Application for a non-material amendment following a grant of planning permission.

Unit:		House number:	24	House suffix:	
House name:	YELLOW HAMMERS				
Address 1:	SEA LANE				
Address 2:	MIDDLETON ON SEA				
Address 3:					
Town:	BOGNOR REGIS				
County:	W. SUSSEX				
Postcode (optional):					
Description of location or a grid reference. (must be completed if postcode is not known):					
Easting:		Northings:			
Description:

EXTENSIONS AND ALTERATIONS

M/25/11

PROPOSED GROUND FLOOR PLAN SCALE 1:100

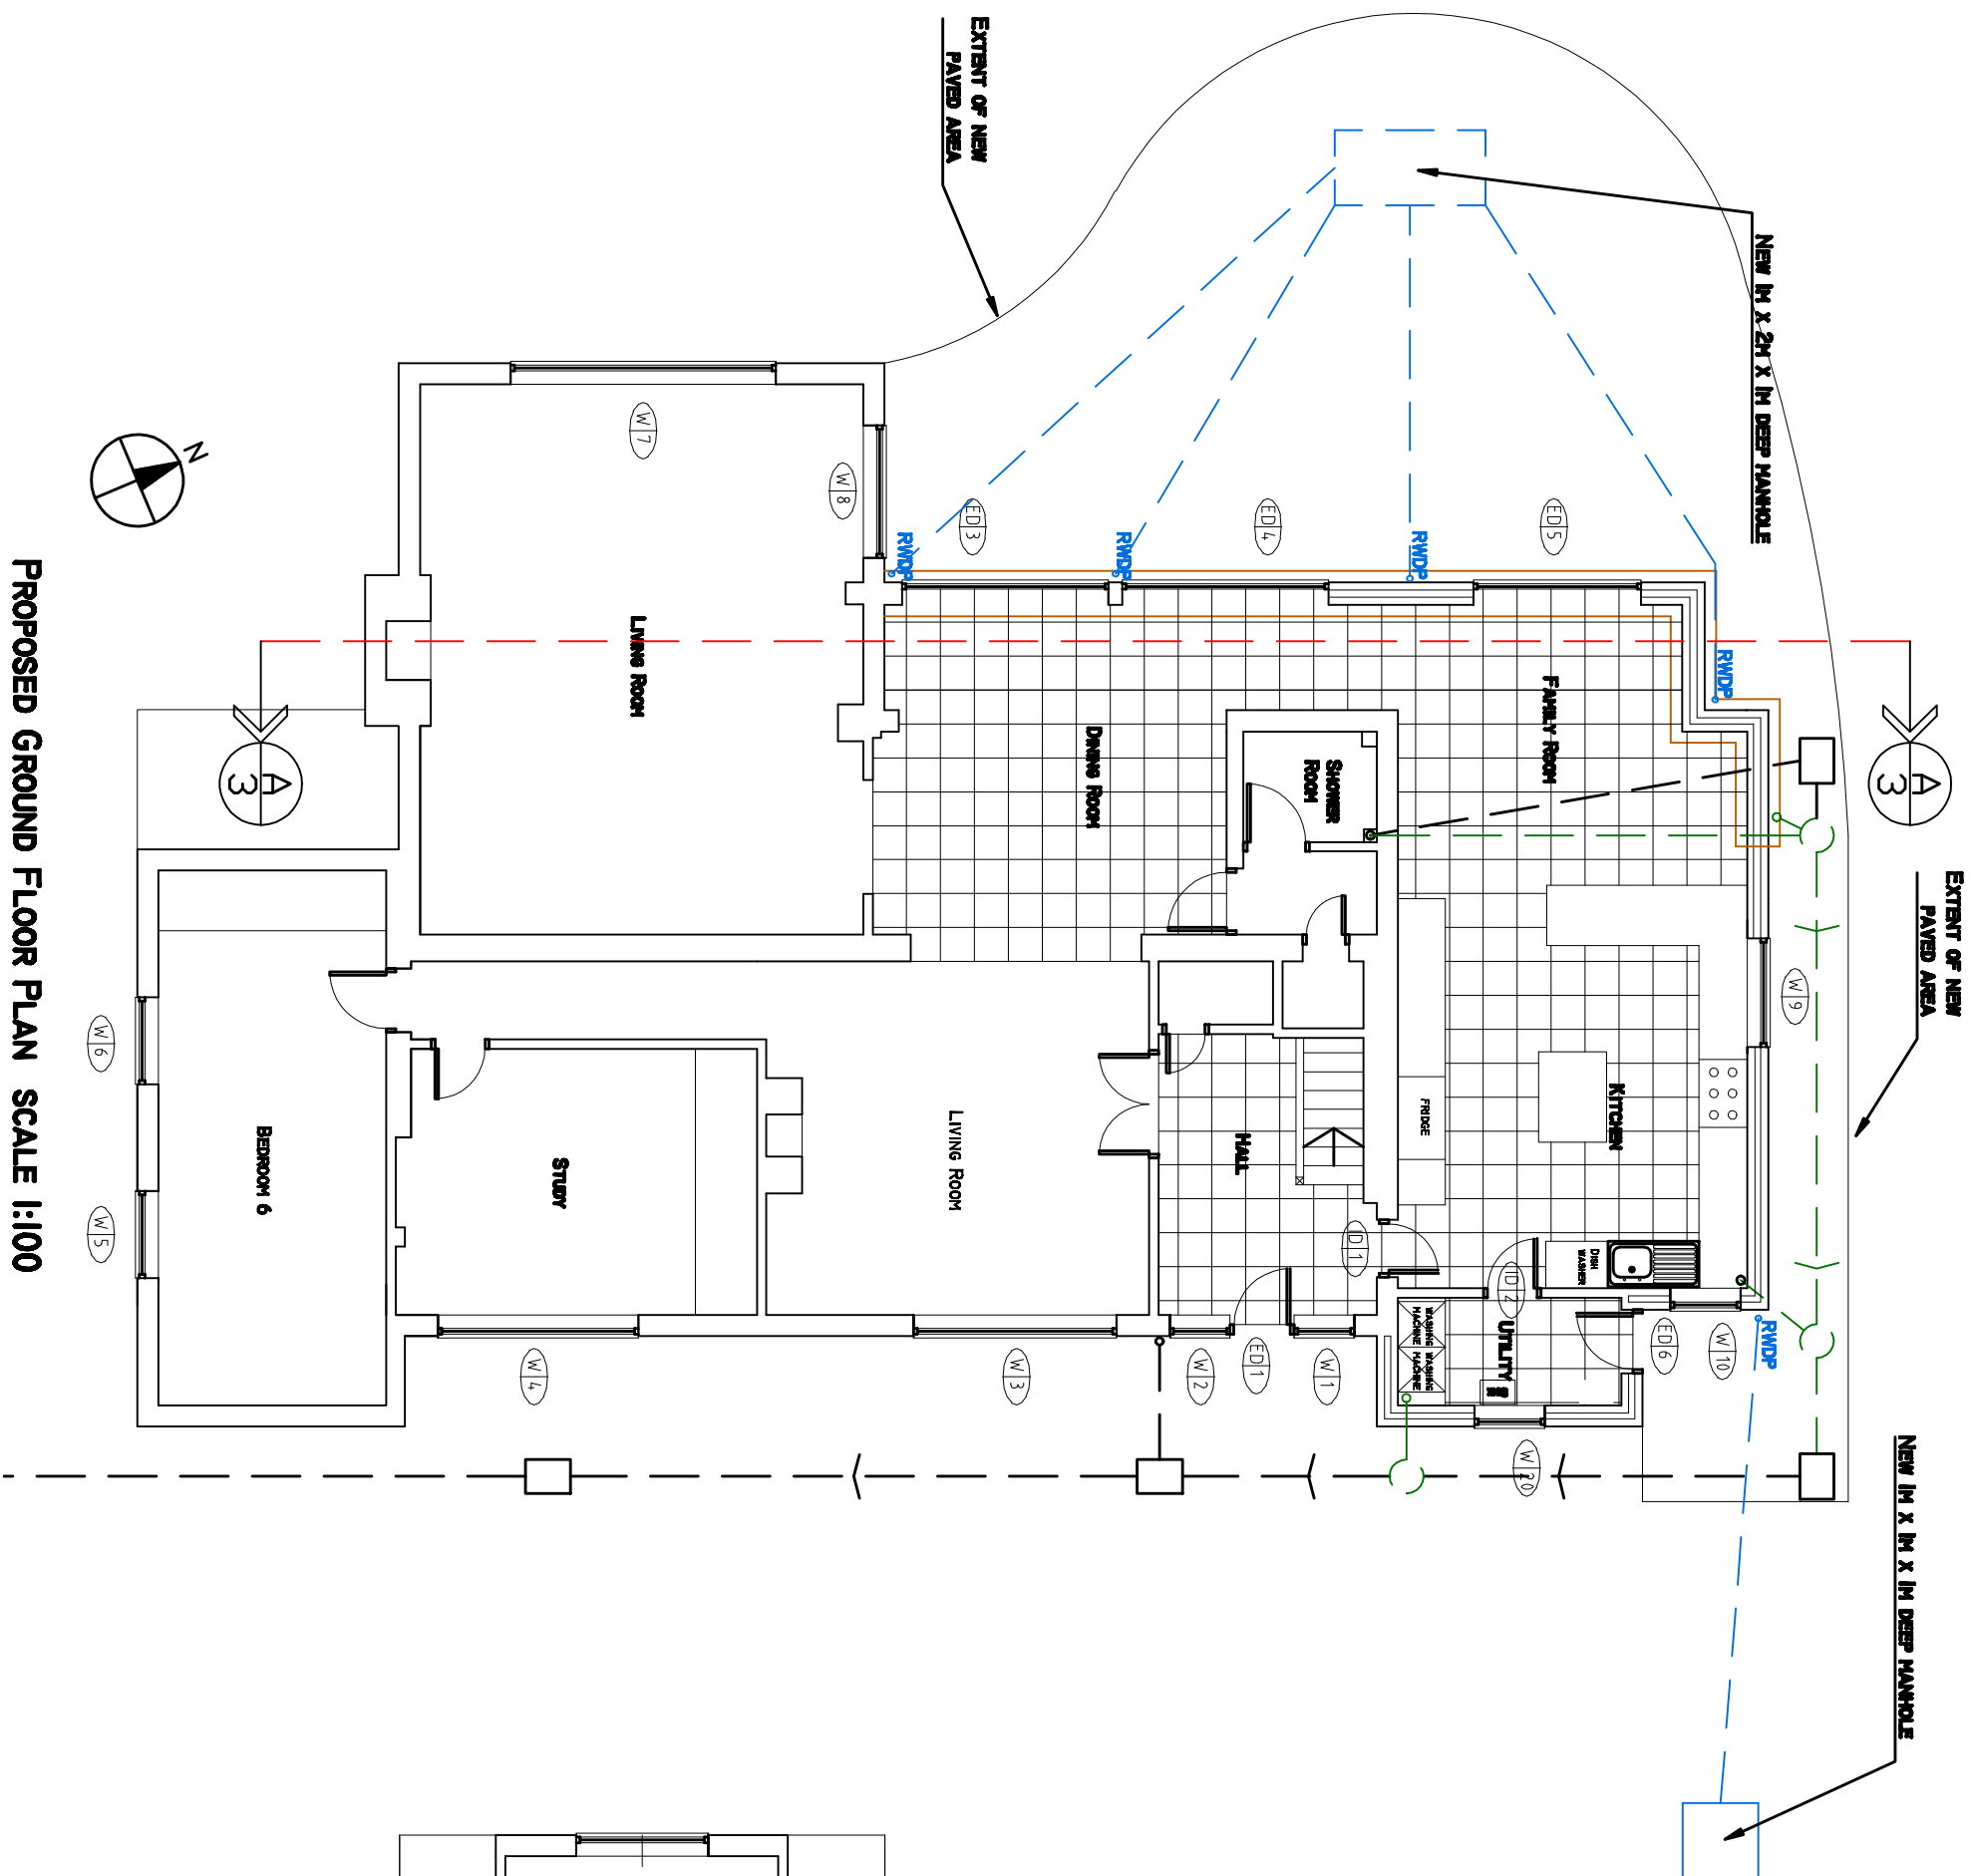
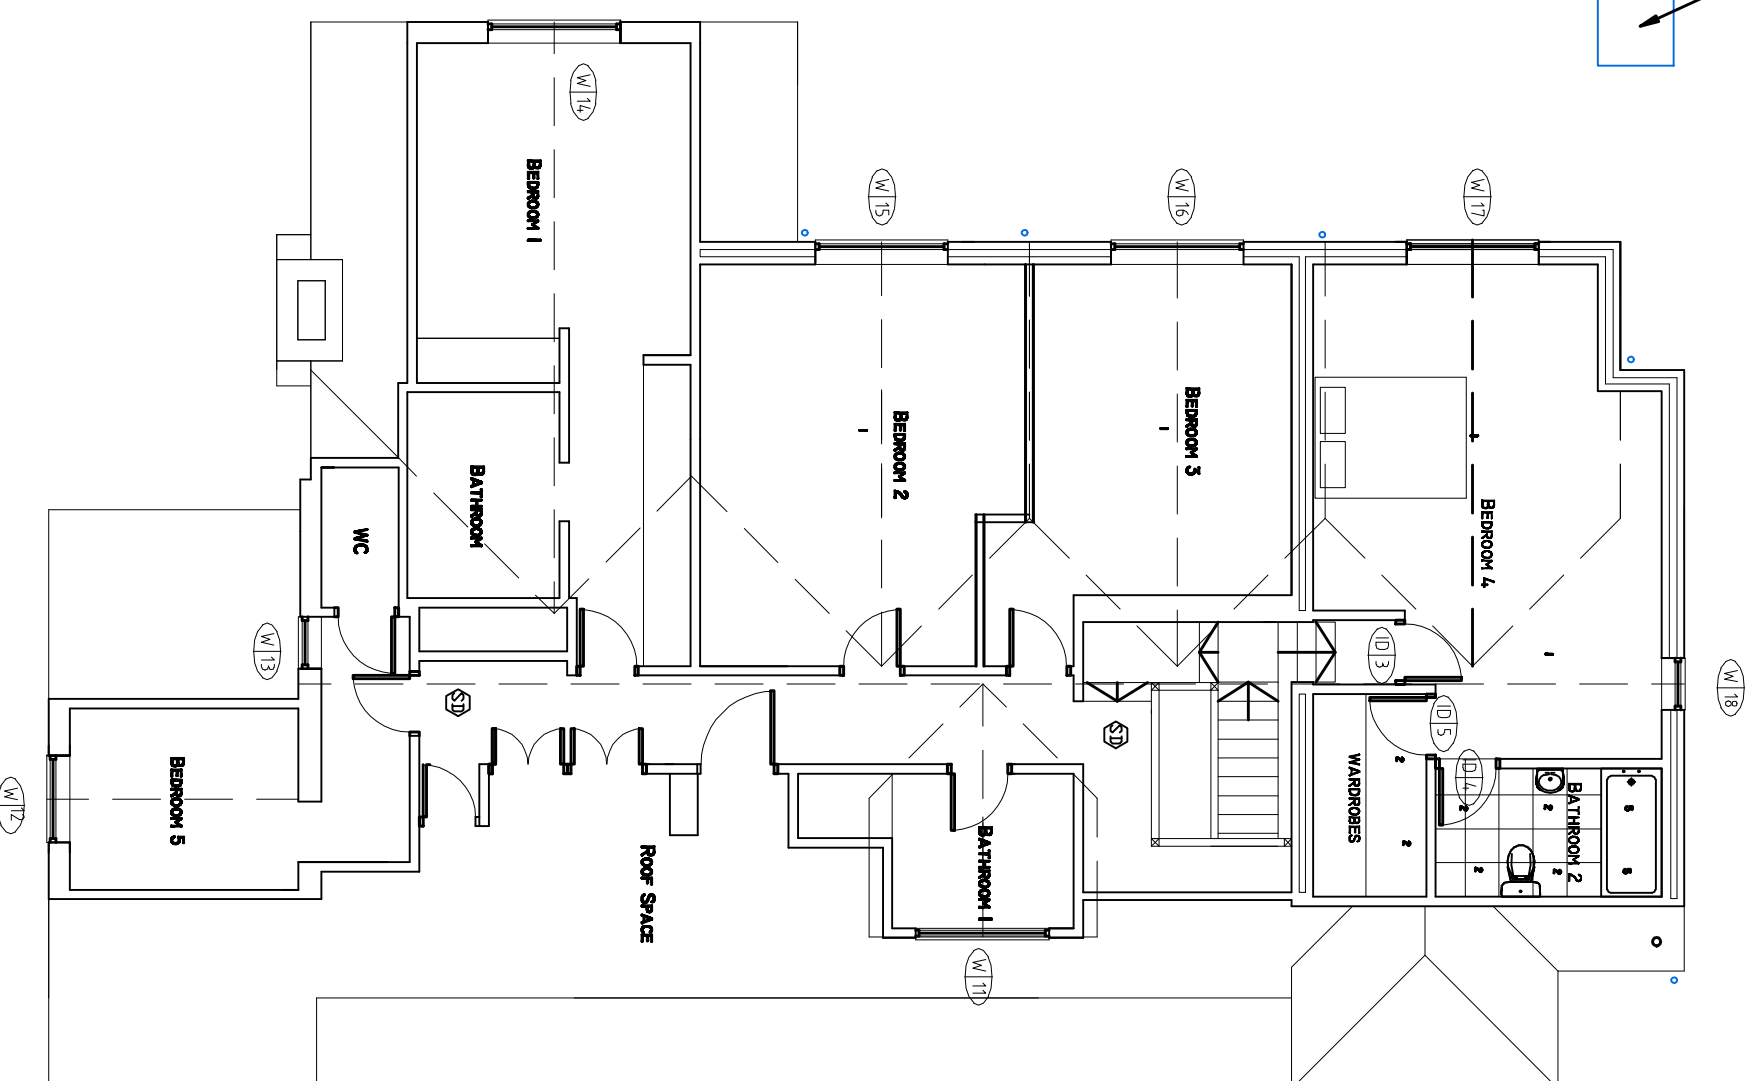
- WEATHERBOARDING ADDED ABOVE FIRST FLOOR LEVEL TO GABLES IN LIEU OF PAINTED PEBBLEDASH. (TO EXISTING & PROPOSED) (WEATHERBOARDING TO BE ETERNIT OR SIMILAR MAINTENANCE FREE TYPE).
- WINDOW ADDED TO UTILITY ROOM.
- REAR PATIO DOORS WIDENED
